Immingham Green Energy Terminal

10.7 Proposed Further Changes Notification Report

May 2024

Document Reference: TR030008/EXAM/10.7

Drawing Number	Project	Originator	Volume	Rev
60673509	-ACM	-XXX	-	P02
Location	Type	Role	Number	
ZZ	-DR	-CH	0002

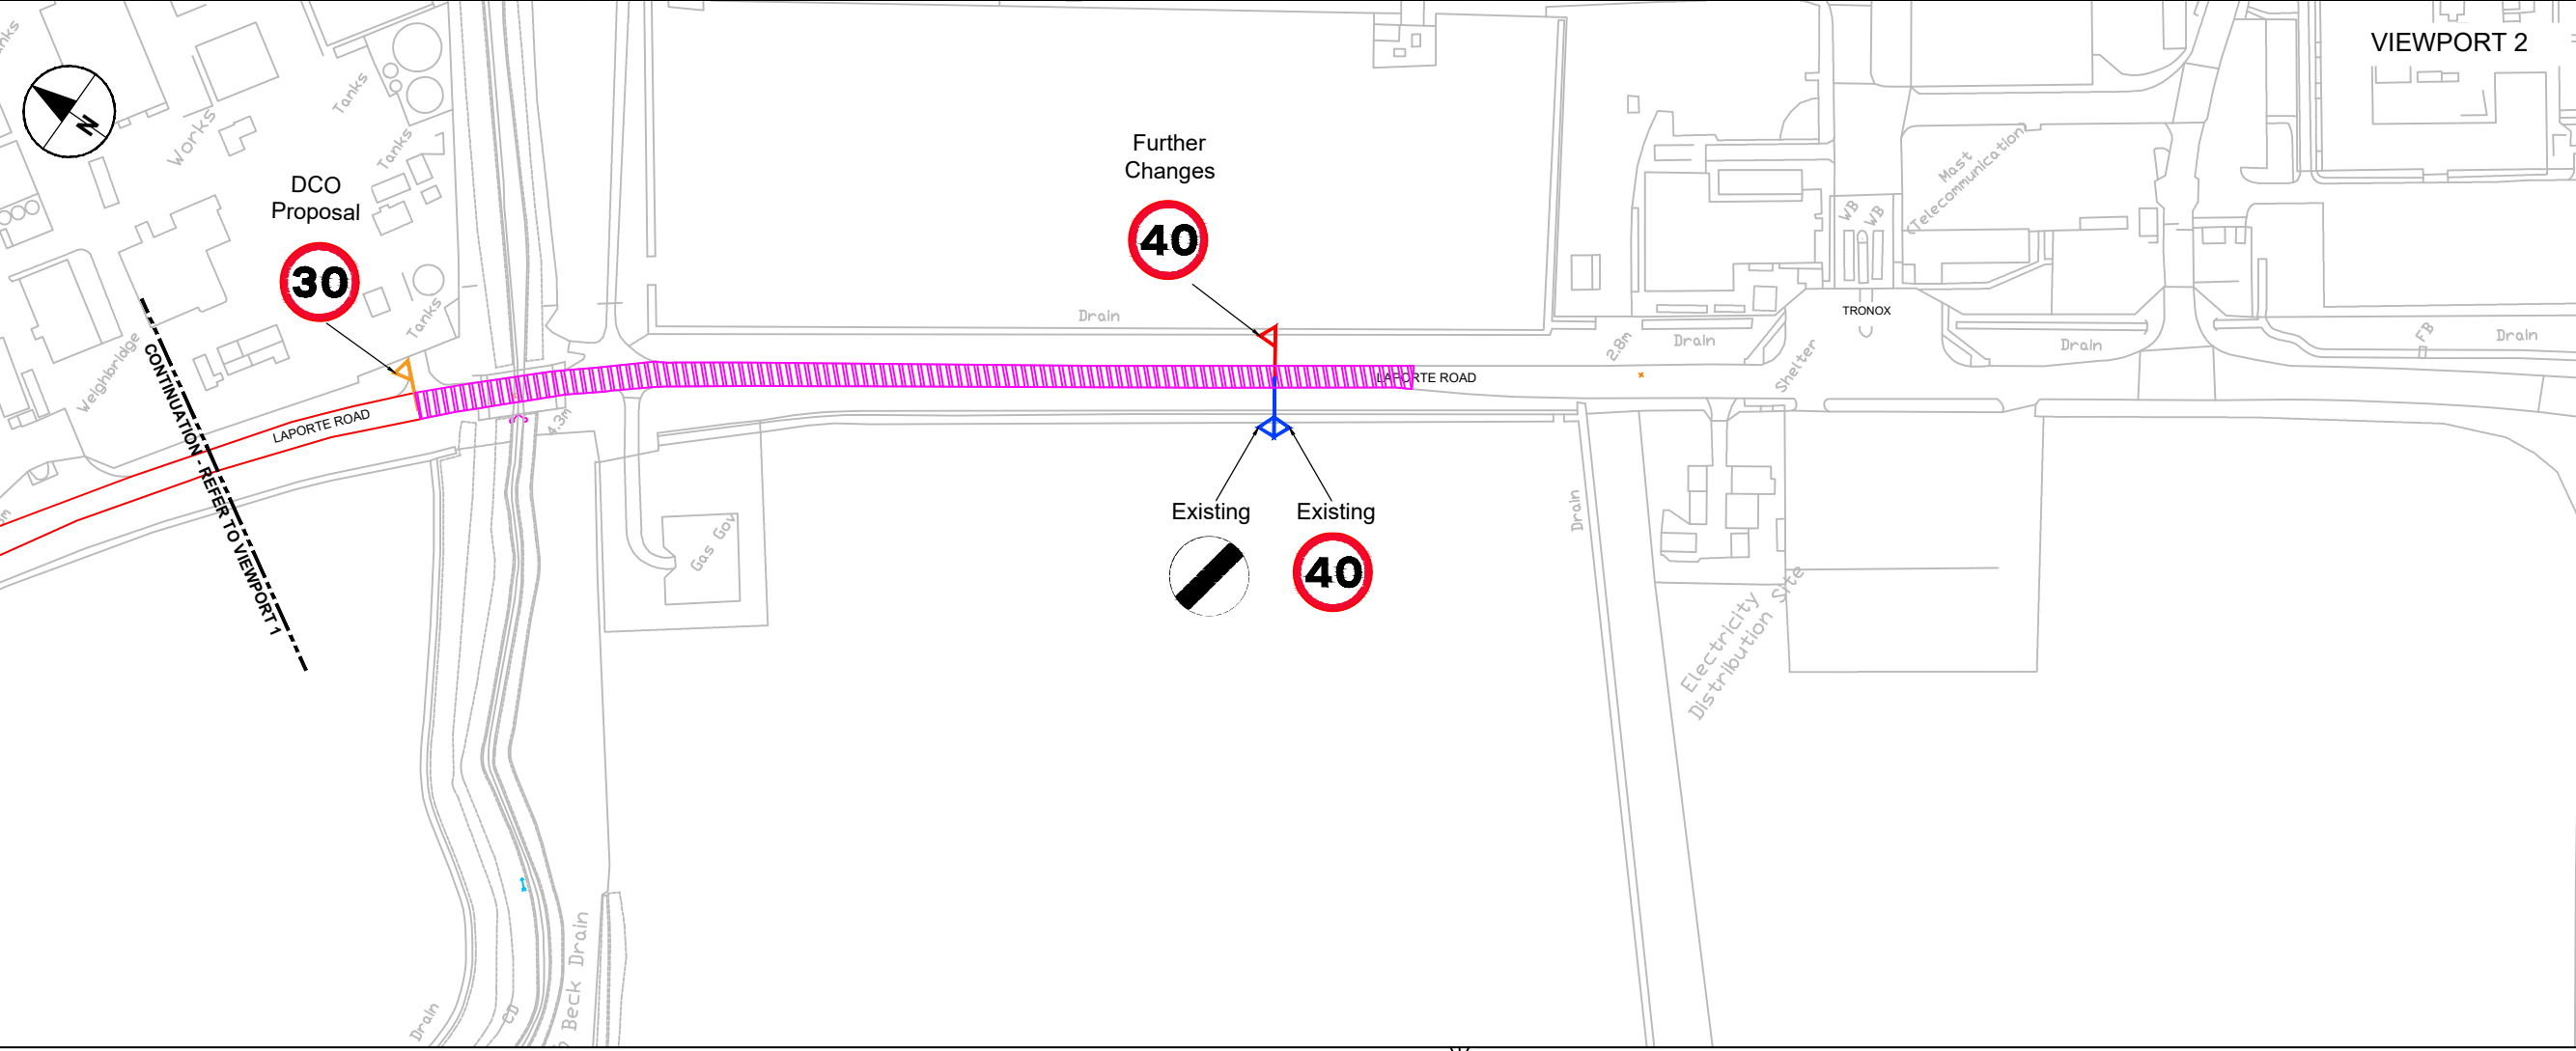
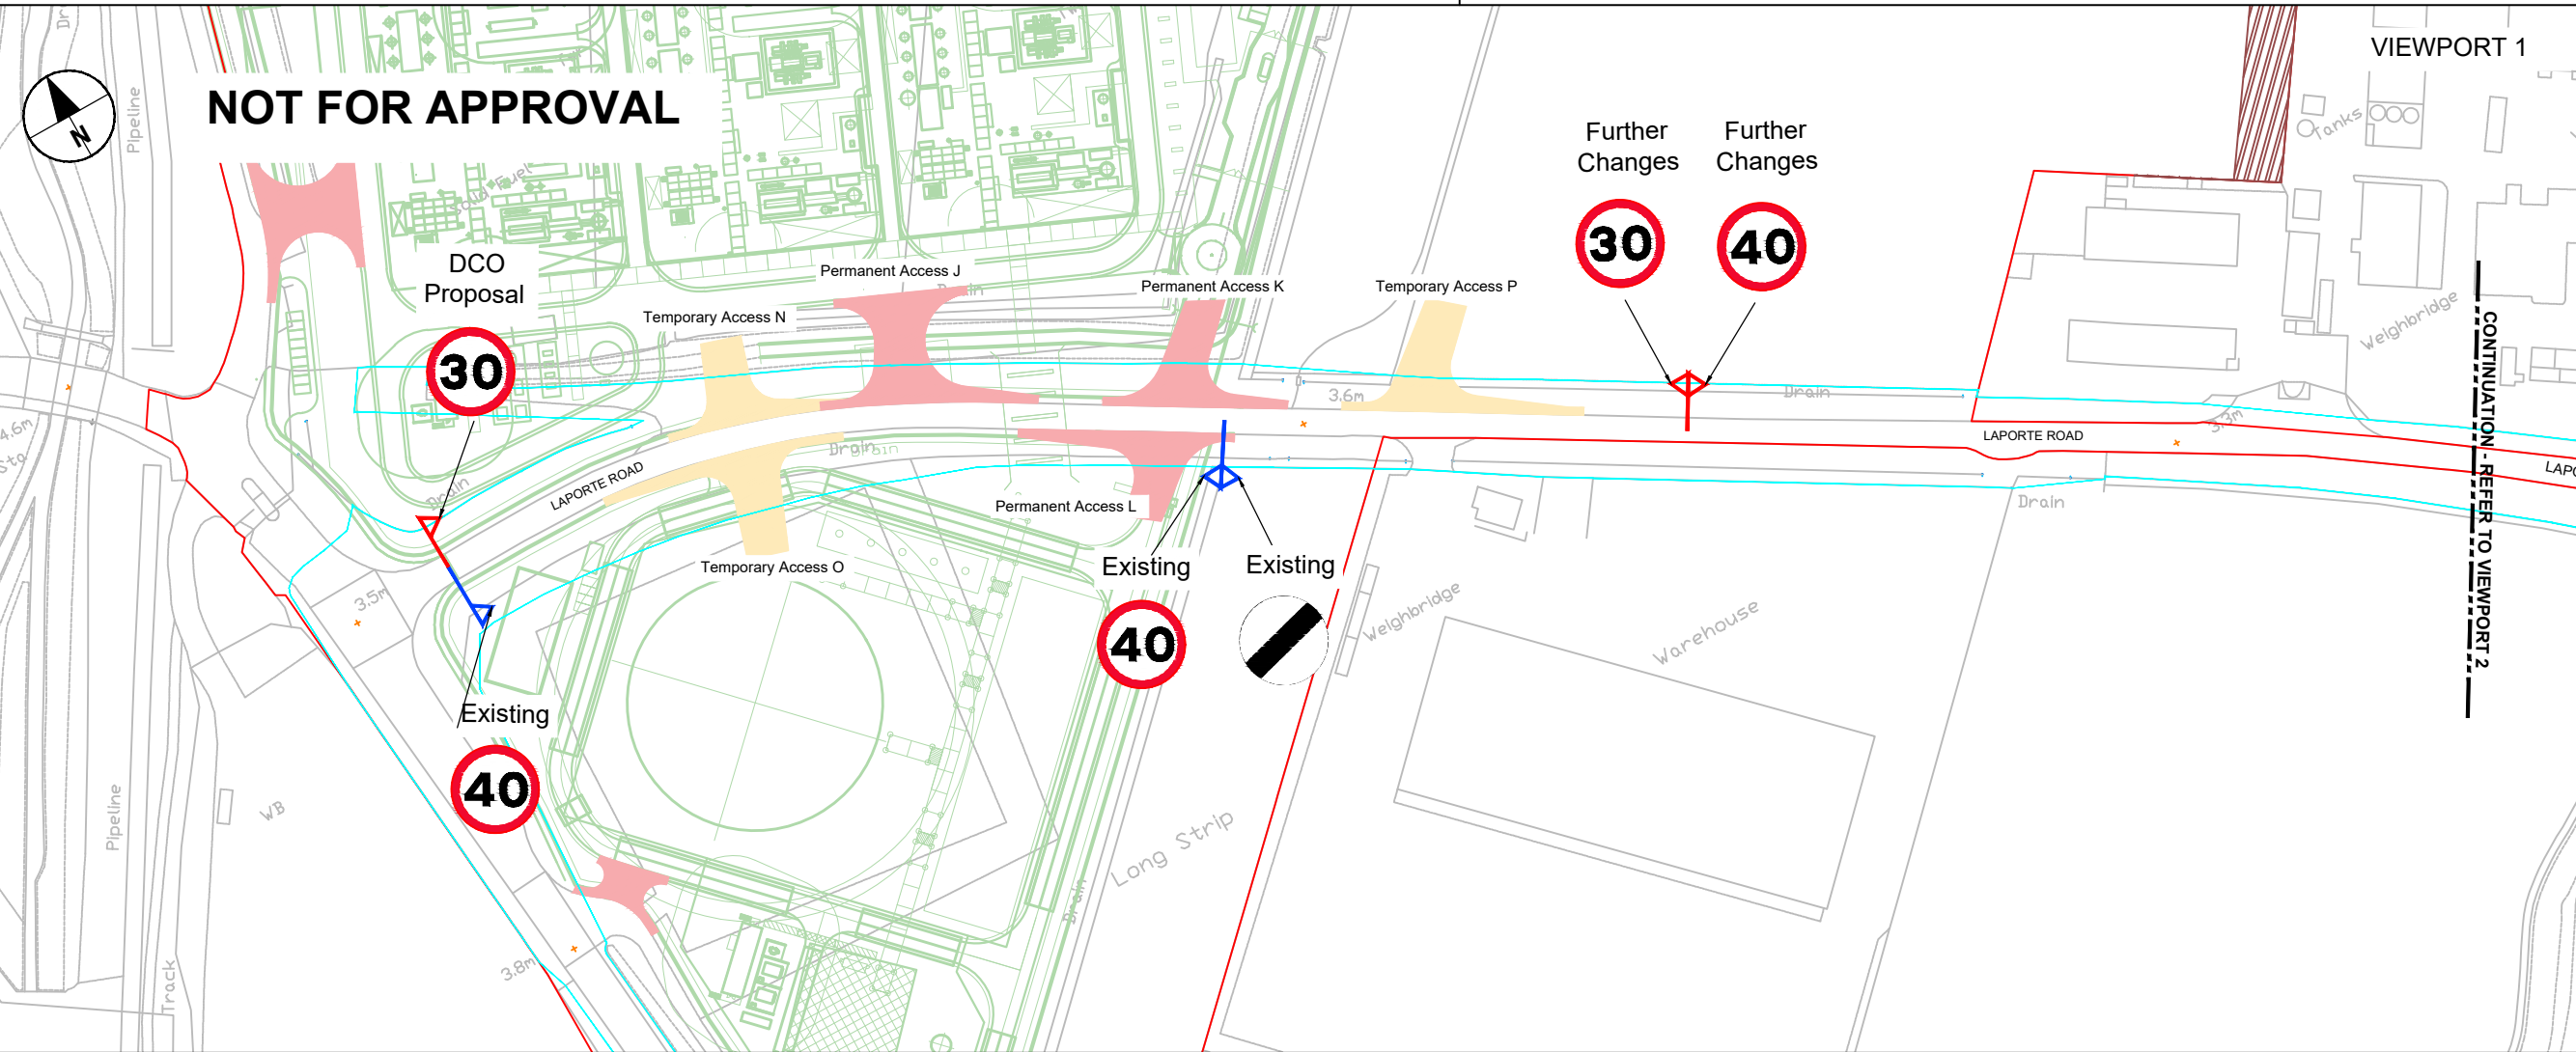
- 2.5 Proposed Change 5(c): Adjustments to speed limit change on Laporte Road & extension of Order limits
- 2.5.1 Adjustments are proposed to the way that the speed limit change agreed with NELC is to take effect along Laporte Road. As shown on the **Traffic Regulations Measures Plan [REP3-018]**, the Application currently proposes that the speed limit for a length of Laporte Road is reduced permanently to 30mph past the entrances to Work No. 3 and Work No. 5.

- 2.5.2 NELC Highways has requested that the limits be consolidated in order to better reflect existing controls and to remove what would be a short section of 60mph limit, thereby smoothing the speed limit changes.

- 2.5.3 It is therefore proposed that the 30mph limit will apply to Laporte Road between the junction with Queens Road and the eastern extent of Access P (Access P is shown on the **Street Works and Accesses Plan [REP3-016]**). A limit of 40mph is proposed from the eastern extent of Access P for approximately 600m to the point where the existing limit on Laporte Road reduces to 40mph. This will require a short extension (approximately 305m) of the Order limits along the public highway of Laporte Road to encompass the new 40mph section. **Appendix 1** illustrates the location of the proposed change. **Appendix 2** illustrates the proposed adjustments and the proposed extension to the Order limits to reflect Proposed Change 5(c) and **Appendix 4** illustrates the locations of the proposed changes to speed limits.
